Our Ref: BR/274/21/DOC

Approval of details reserved by condition imposed under ref BR/324/17/PL relating to Condition Nos 8 - landscaping scheme, 9 - materials & finishes, 11 - visibility splays, 12 - pedestrian visibility splays and 13 - covered & secure cycle parking spaces.

279-285A Chichester Road Bognor Regis PO21 5AH

Condition Number 11

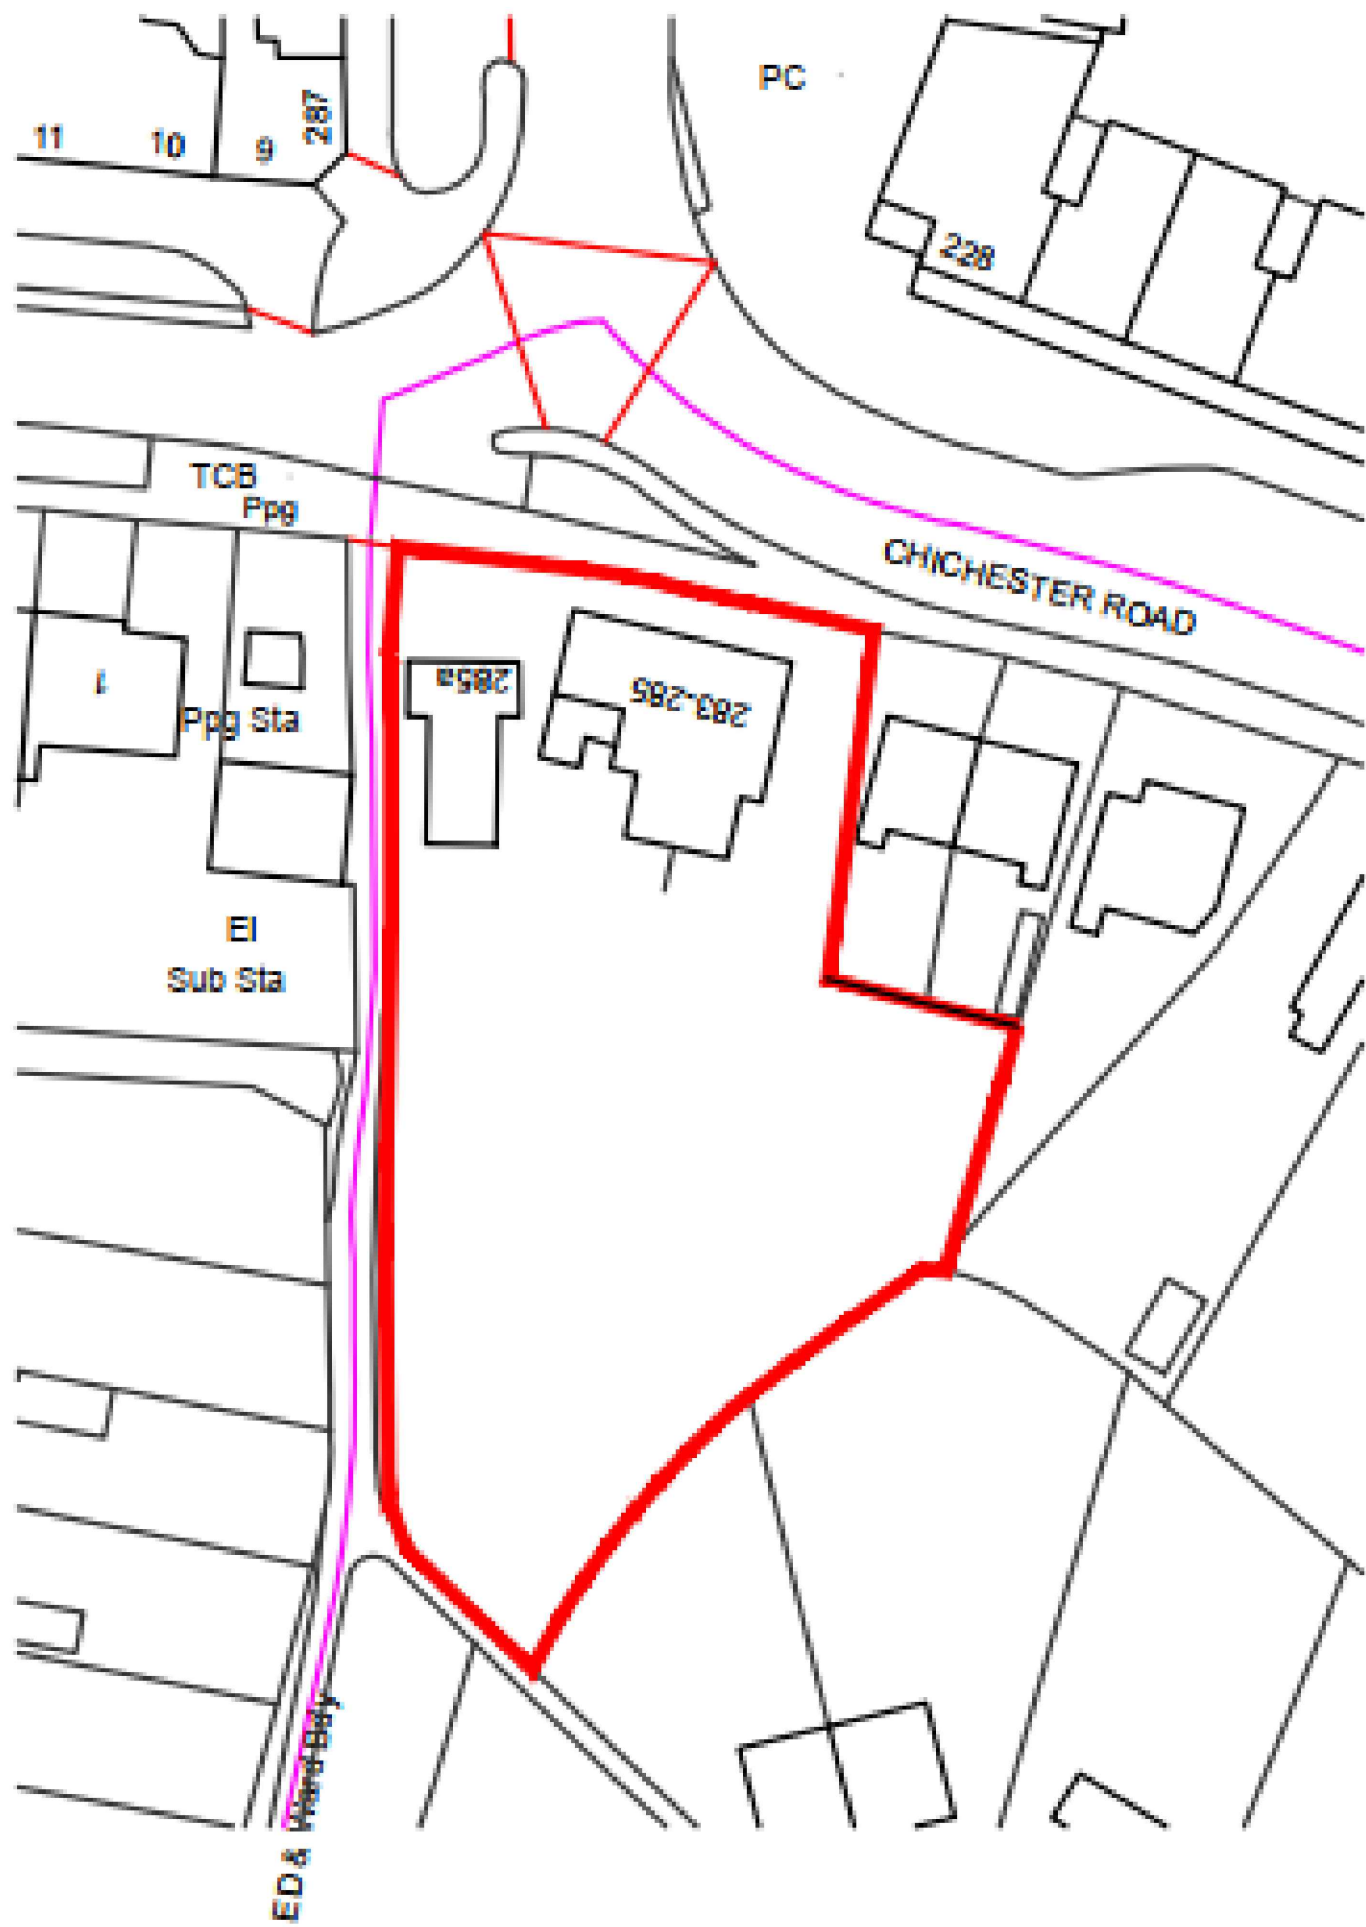
The details of visibility as shown on drawings "Section 278 Visibility Splay Extent Plan"(502 Rev P) and "Section 278 Agreement Plan (500 Rev P) demonstrate that the required visibility splays can be achieved. WSCC Highways therefore consider that this condition may be discharged.

The condition is therefore fully discharged insofar as the submission of details relates and on the understanding that the visibility splays will be implemented in accordance with the submitted drawings and permanently retained thereafter.
